Project Name: LANDS OF RABADI & SCHWARTMAN PACKING CO.

SUBJECT: Project # 1007545, 08DRB-70462 Minor – Preliminary/Final Plat Approval, Lot 3, Tract O, Lands of Rabadi & Schwartzman Packing Co, Located on Mulberry SE Between Gibson Blvd. SE and Sunport Blvd. SE.

DRB Comments

TO: Jack Cloud, DRB Chairman
FROM: Suzanne Busch, Principal Engineer 
SUBJECT: Project # 1007545 – Mulberry Properties

Plat of
Tracts A and B
Mulberry Properties
Albuquerque, Bernalillo County, New Mexico
October 2008

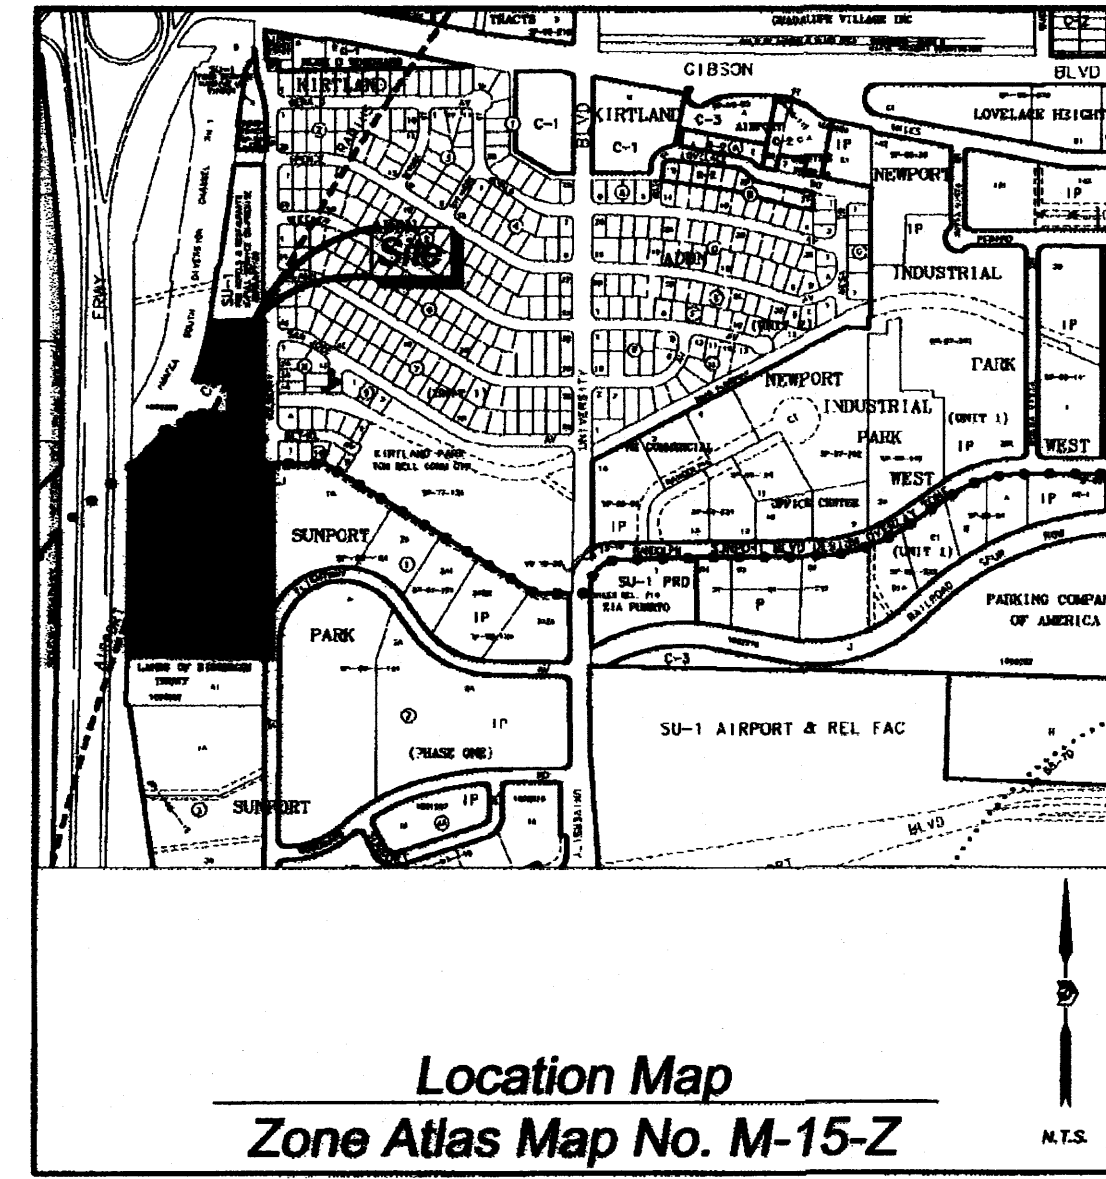
This property is located on the Schwartzman landfill. The following disclosure statement should be added to the cover sheet of the plat (it provides a signoff place for me as well):

The subject property is located on a former landfill (Schwartzman). Due to the subject property being on a former landfill, certain precautionary measures may need to be taken to ensure health and safety of the public. Recommendation made by a professional engineer with expertise in landfills and landfill gas issues (as required by the most current version of the *Interim Guidelines for Development within City Designated Landfill Buffer Zones*) shall be consulted prior to development of the site.
